Department of Primary Industries

**Bringelly Road Business Hub, Bringelly Road, Leppington (SSD-6324)
Adequacy of the draft Environmental Impact Statement**

Bringelly Road Business Hub (SSD 6324) Request for comment on adequacy of EIS Comment by NSW Office of Water

Indicative Master Plan
 13525 | Bringelly Road Business Hub

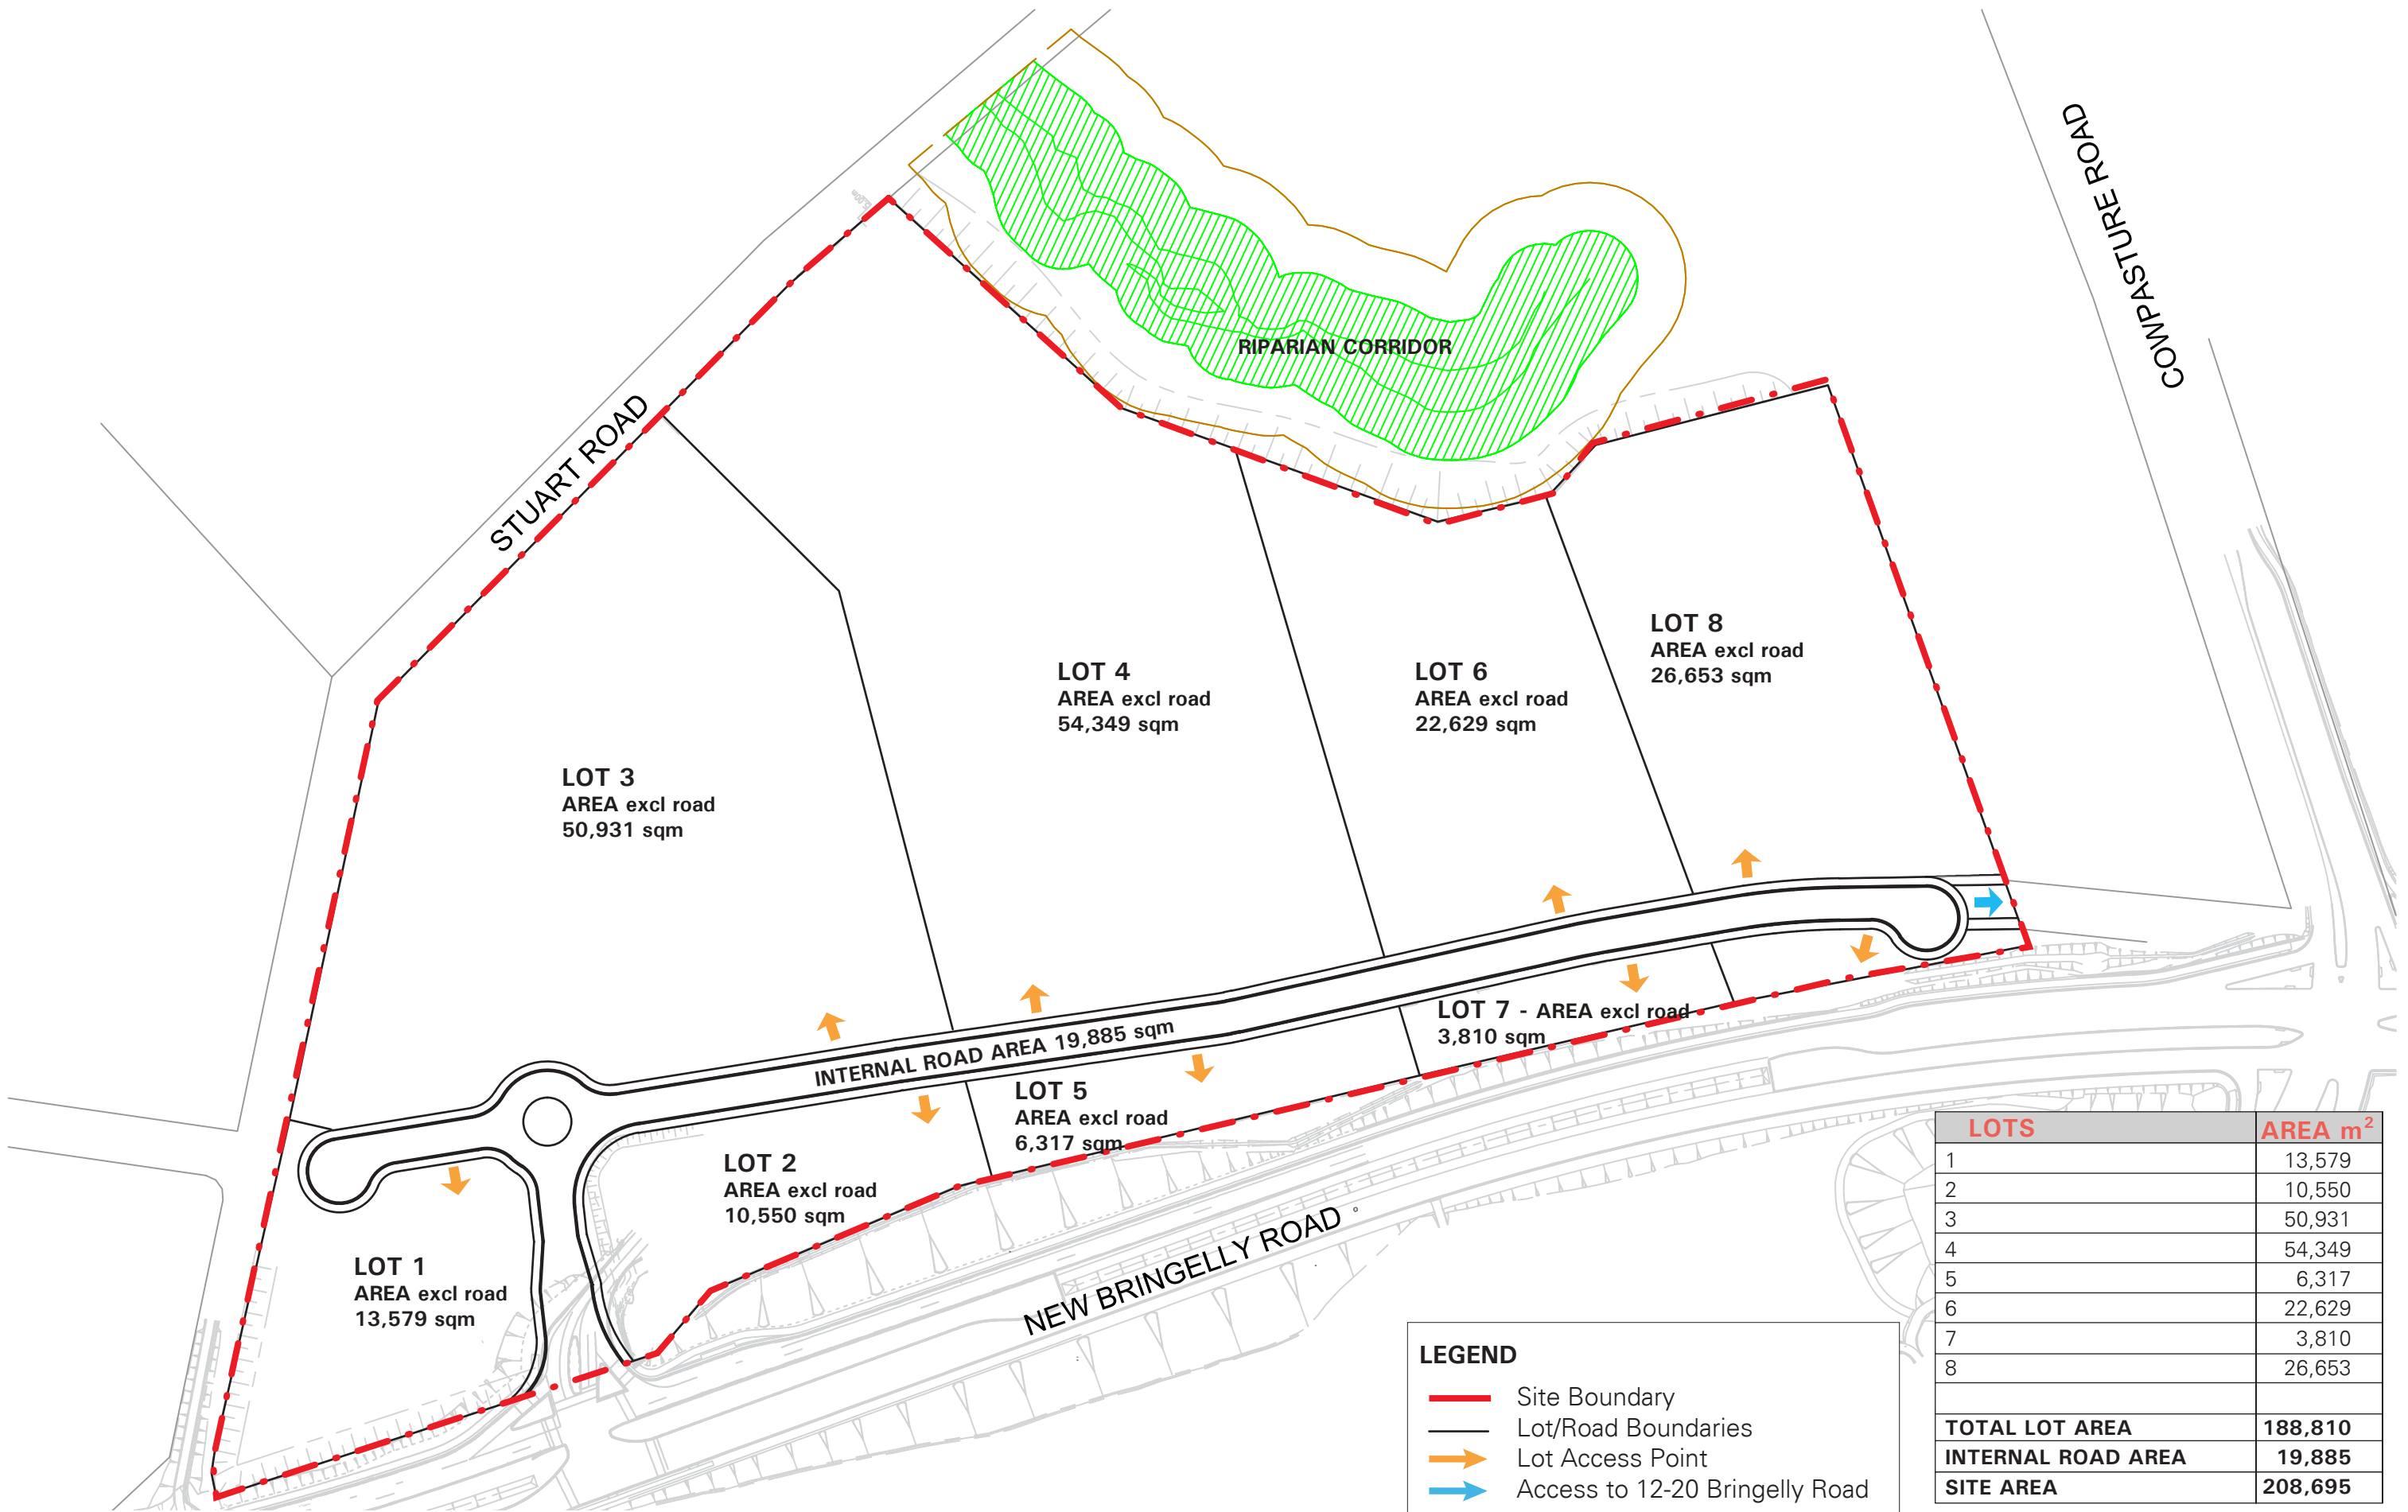
There are inconsistencies between documents about the northern part of the site which is adjacent to the riparian corridor, where the EIS indicates native plantings are to be used (see Section 3.7, page 30), the Indicative Master Plan (Appendix A) appears to show a hardstand area/site access road is proposed in this location while Appendix E (Landscape Plans) shows a swale is proposed to be located along the northern boundary. Further details are required on the proposed treatment along the northern boundary, particularly as this area is adjacent to the riparian corridor. If a swale is proposed to be constructed it is unclear what plant species are proposed to be planted in the swale, or the width of the swale.

8. This is the shift in turnover from 2014 to 2021 after the opening of the new development.
9. This is shift in turnover from 2013 to 2018 divided by the base turnover in 2014.

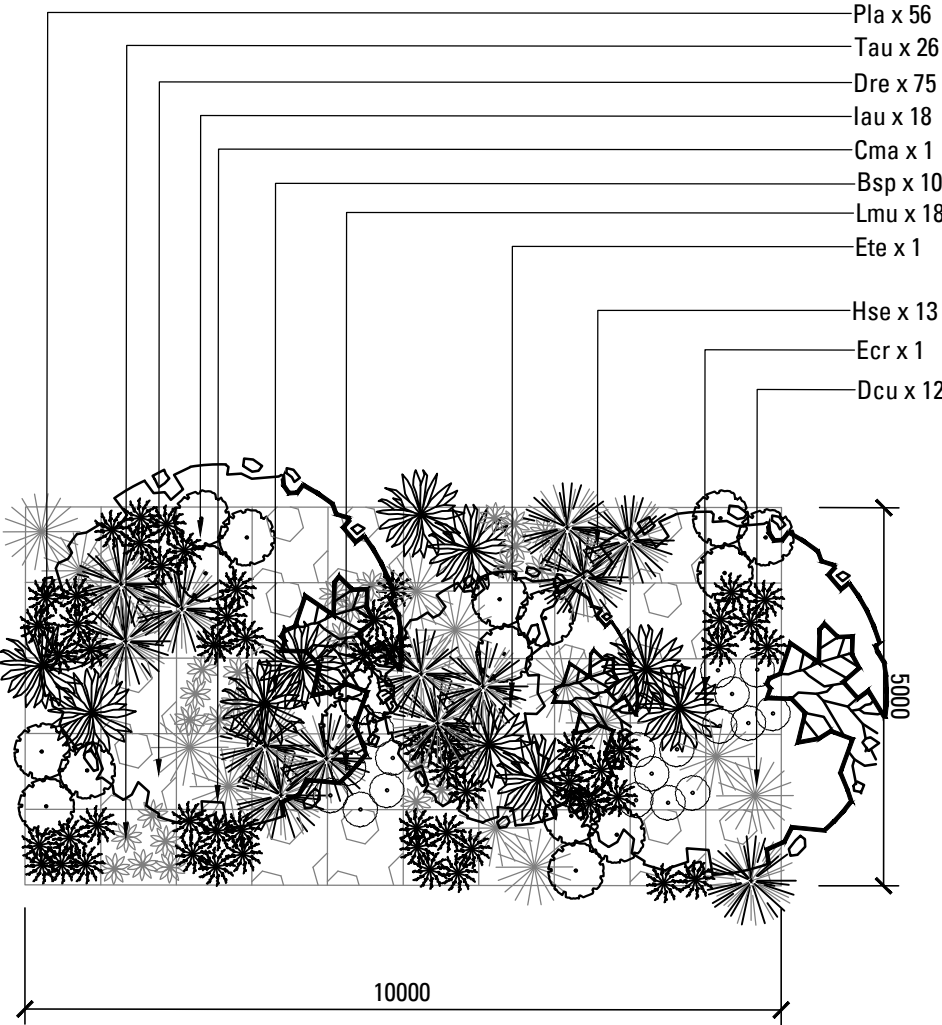
As the northern part of the site adjoins the riparian corridor in Bedwell Park, it is recommended any landscaping, particularly adjacent to the corridor consists of native trees, shrubs and groundcover species from the relevant local vegetation community to reduce watering requirements at the site and enhance the riparian corridor and the biodiversity value it provides. It is recommended the planting of local native species adjacent to the riparian corridor is included as a mitigation measure.
